REPORT UPDATE

Application No: AL/114/09/

PLANNING APPLICATION REPORT

PROPOSAL: Proposed tourist units in redundant farm building- amendment to AL/92/08 (in lieu of the B1 use approved) - This application is a Departure from the Development Plan

Drawn by: MJW Checked by: GP
Scale: 1:100 Date: OCT 09
Job No: 3719 Drawing: PL200

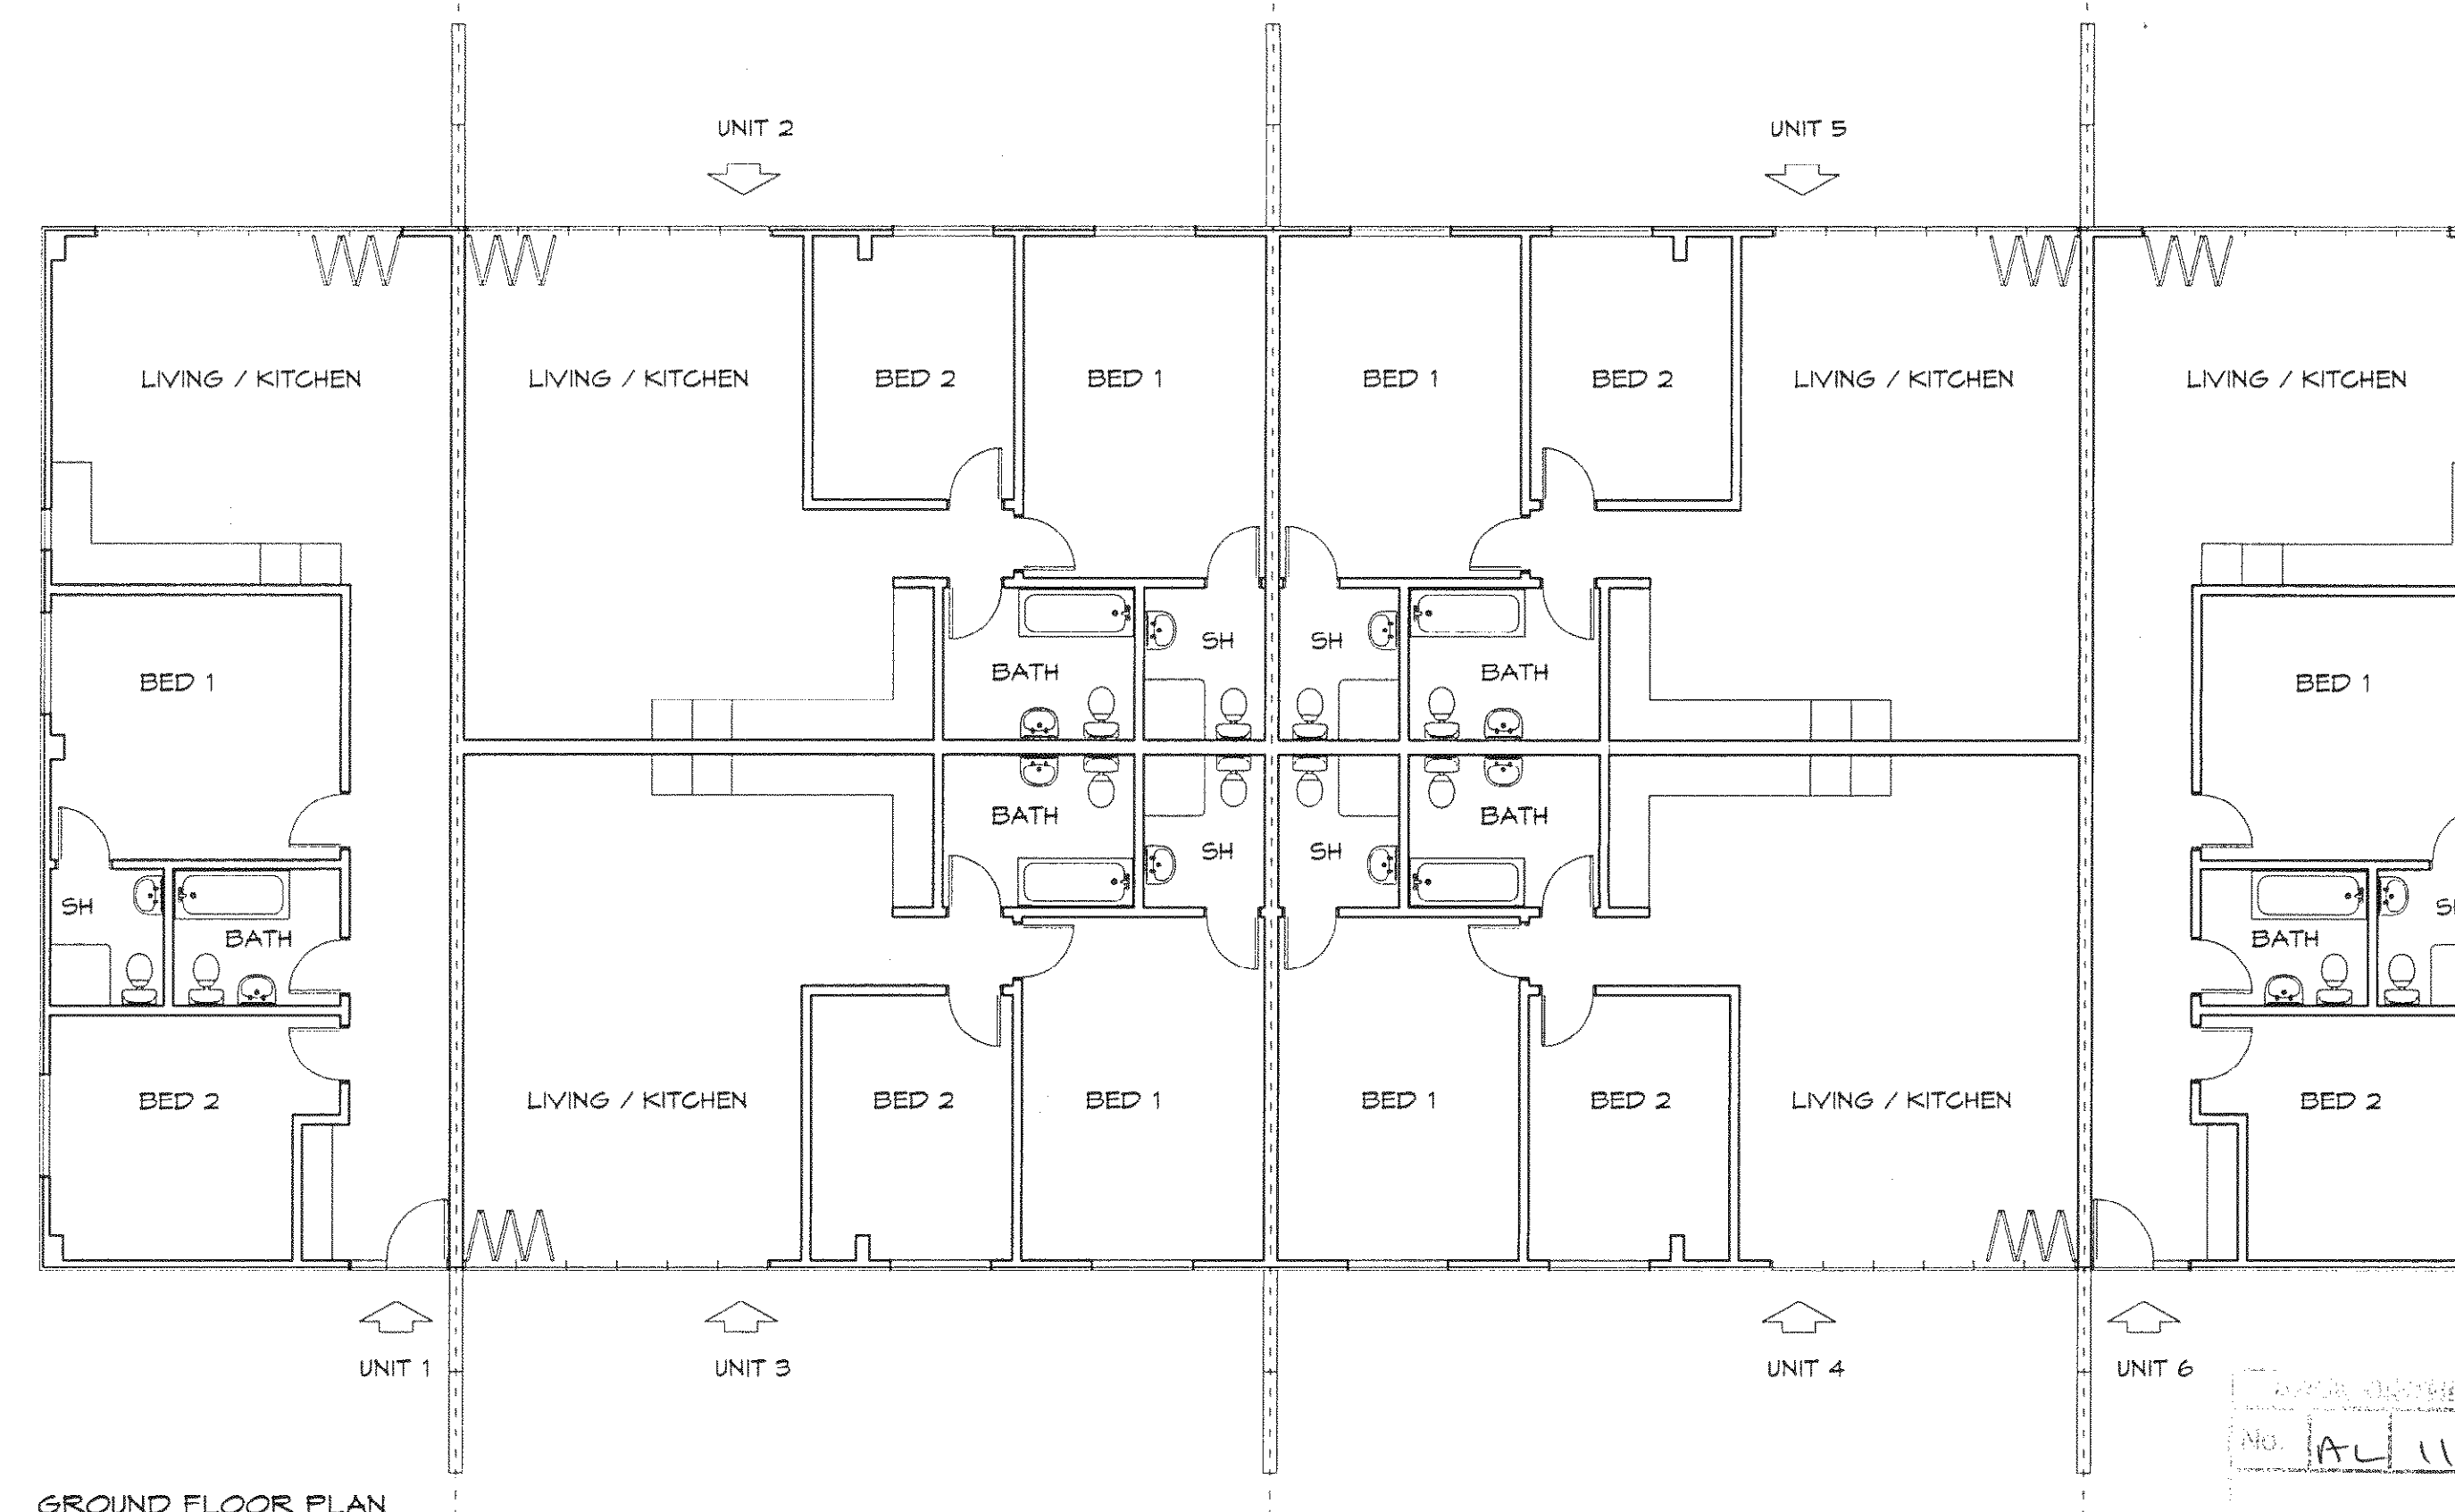
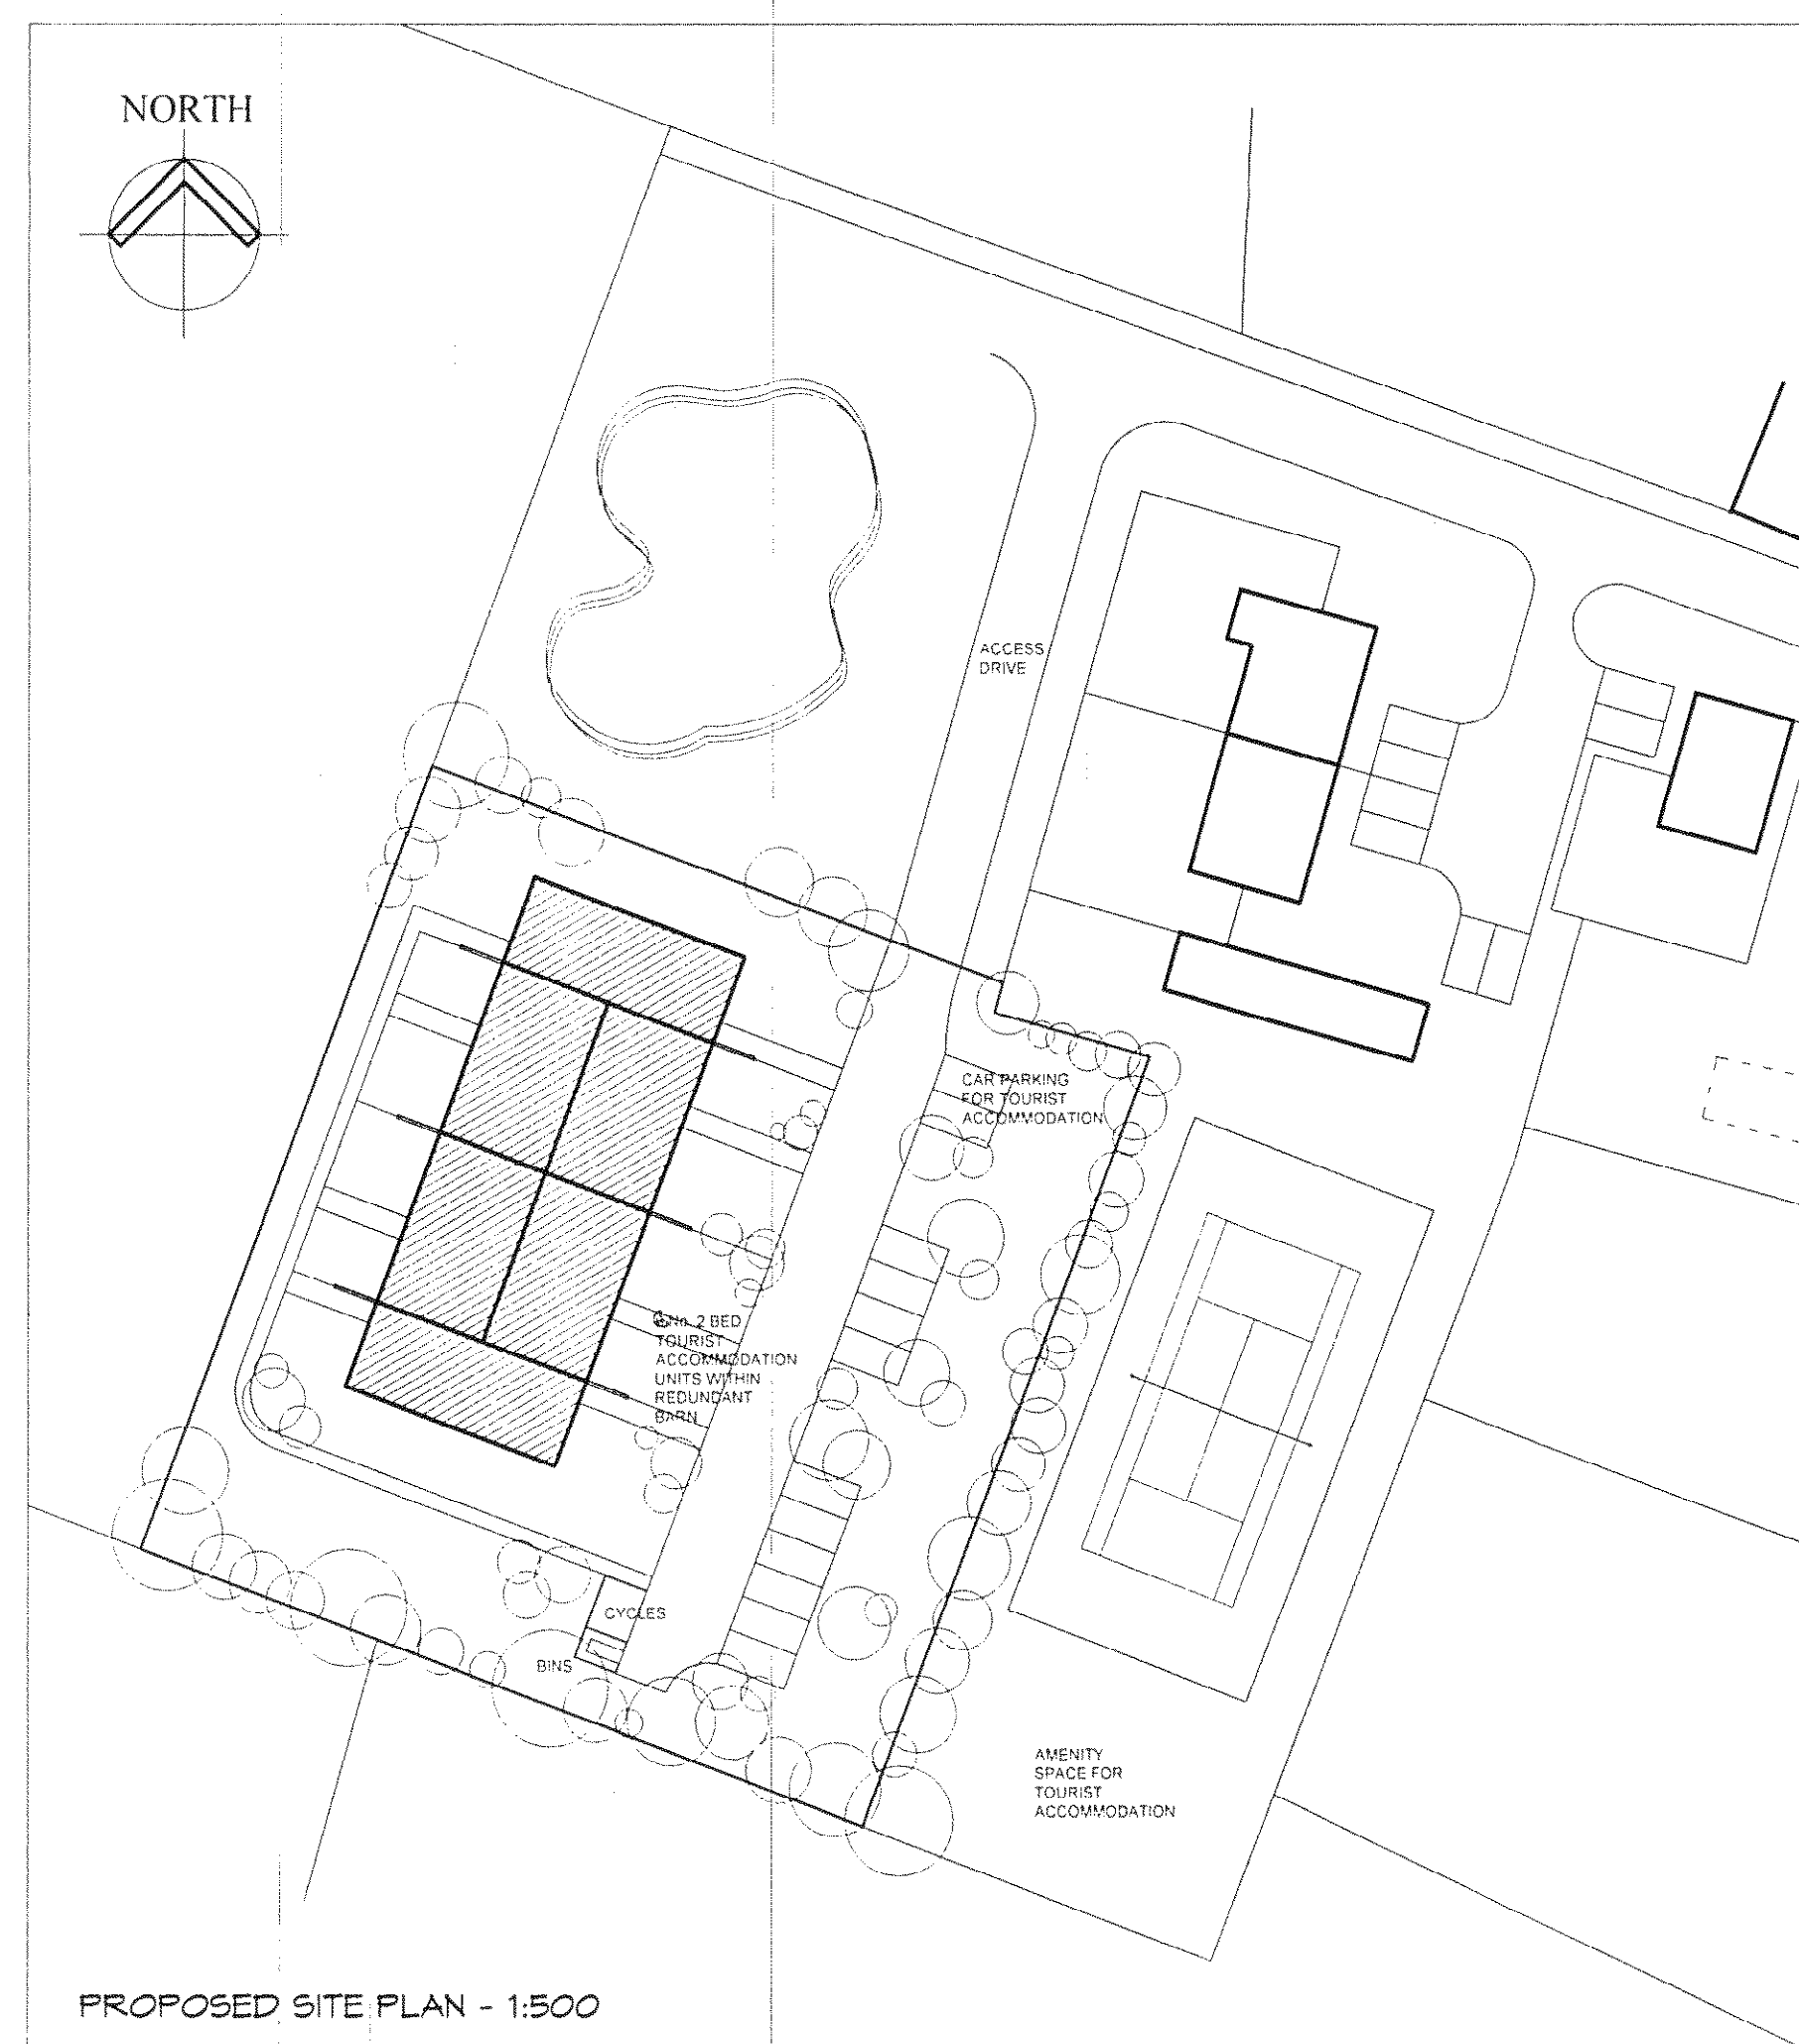
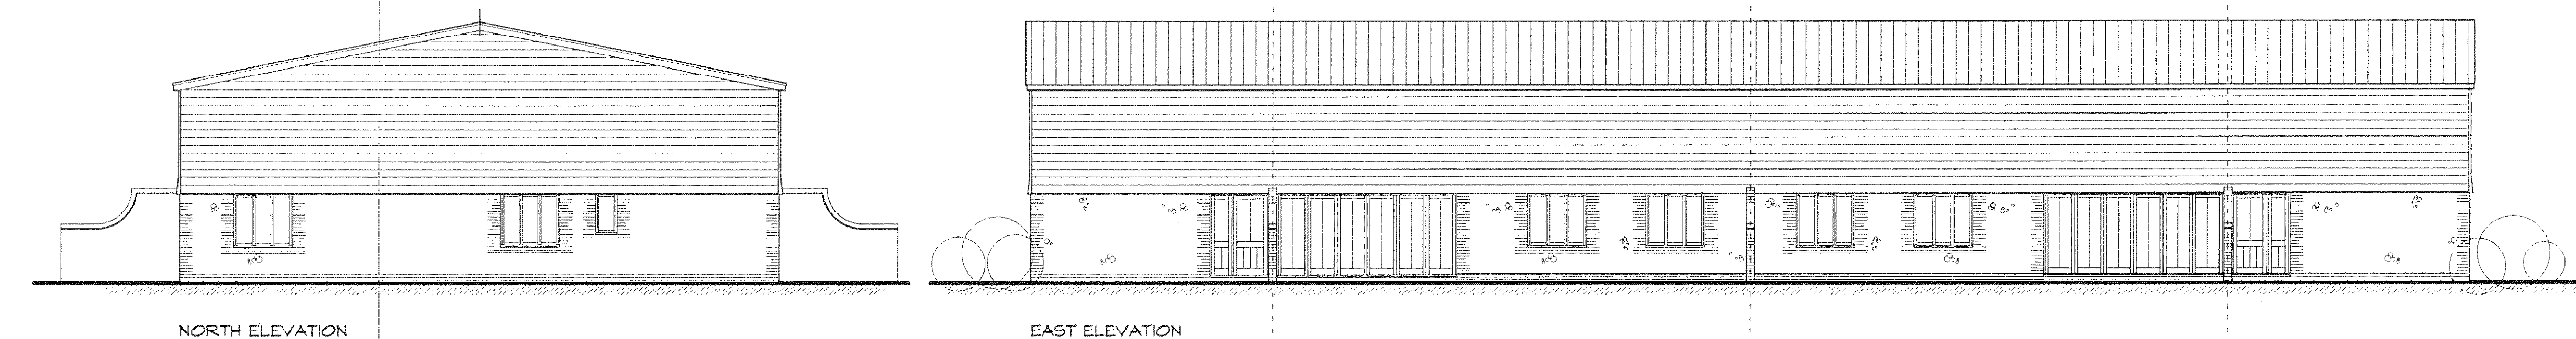
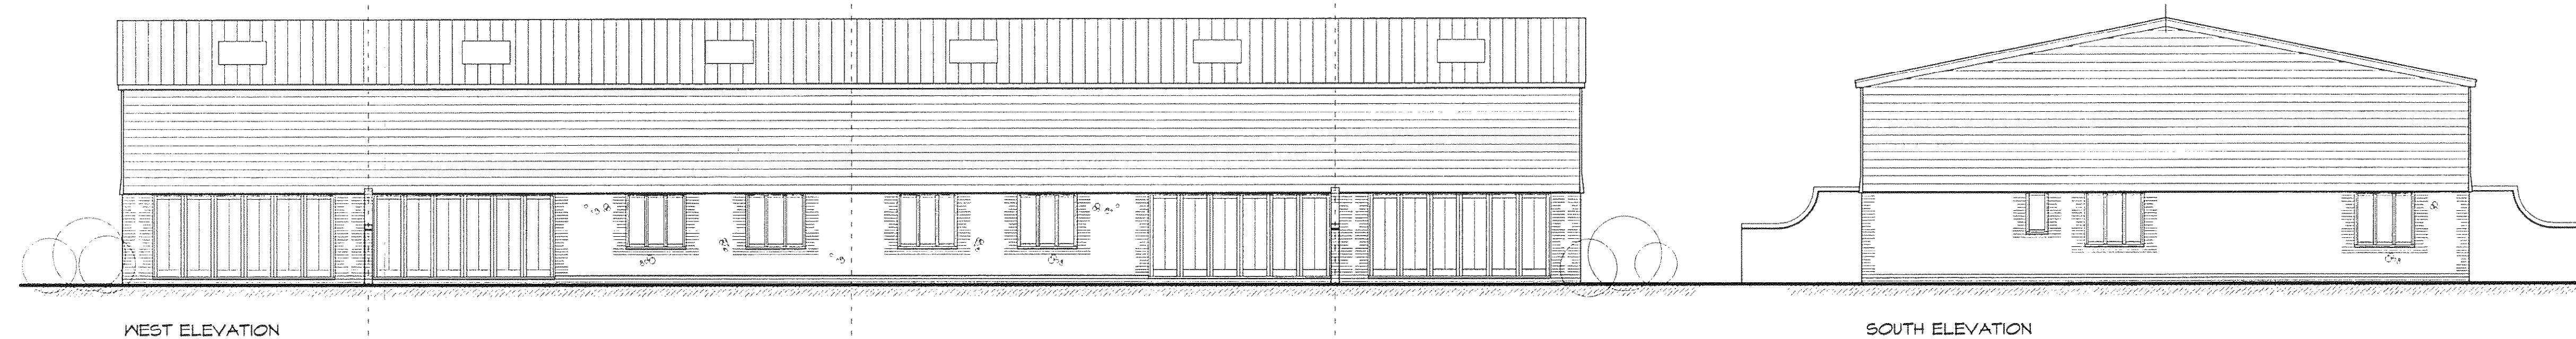
The building is a steel framed structure with asbestos cement cladding to roof and wall areas. The original proposal was to subdivide the unit into B1 uses and re-clad the building with modern compliant panels with some new openings. The latest proposal changes the external appearance treatment and there are more openings and a mixed use of masonry and cladding has been adopted for the walls however the steel frames structure is still retained.

There would, therefore, appear to be no material change in terms of the structural integrity of the barn. Attention would have to be paid to the roofing treatment as a lightweight type roof construction would have to be adopted as per the previous B1 use. There is no material change in terms of structural adequacy of the current framing as compared to the previous approved B1 use. Therefore the proposal should be considered to meet the policy in the content of structural adequacy.

The proposal is considered to conflict with relevant Development Plan policies in that the utilitarian steel framed barn of modern construction was built solely to store animal feed. It is 3 sides with the frontage open bays. The conversion of this structure to tourist accommodation would be contrary to policy in that the conversion could not be compliant with DEV1. The building is not of permanent construction and capable of conversion without rebuilding or significant alteration or extension. The proposed alterations would result in an adverse visual appearance and not sympathetic to its setting.

The proposal does not conform to this policy in that it is not of permanent construction capable of conversion without rebuilding or significant alteration. The nature of a steel framed storage barn can convert easily to a business use B1 as per the existing approval. However, it does not convert to tourist accommodation without significant alteration and possible rebuilding. The resultant design of fenestration would be totally inappropriate with the utilitarian barn and it would result in an unsympathetic structure which would detract from the traditional flint former flint buildings which have had permission to be converted (AL/92/08) to tourist accommodation. Therefore as a matter of principle, the local planning authority are sympathetic and supportive of appropriate barn conversions, however, in this specific case, the proposed conversion is considered inappropriate and non-compliant with the above countryside policies.

The applicant has not submitted a revised structural survey to ascertain that the building could be altered to accommodate the proposed fenestration changes without requiring a significant rebuild. The structural survey submitted under AL/92/08 was submitted on the basis of B1 use and tourist residential use would require more significant alteration. Visually, the proposed alterations to the building are inappropriate in a steel functional barn and would be a visual intrusion detracting from the historic flint barns and brick dairy buildings. Therefore the proposal is considered to be in conflict with the above countryside policies.

- 1 The proposal is unacceptable in that the building is unsuitable for the new tourist accommodation proposed use because it is not a suitably constructed rural building by reason of metal frame and clad design. There is no structural survey submitted to assess the degree of rebuilding or significant alteration. The submitted elevational plans show significant rebuilding and alteration. Furthermore the design of the conversion would result in a visual distraction from the surrounding converted flint and brick barns and conservation area.
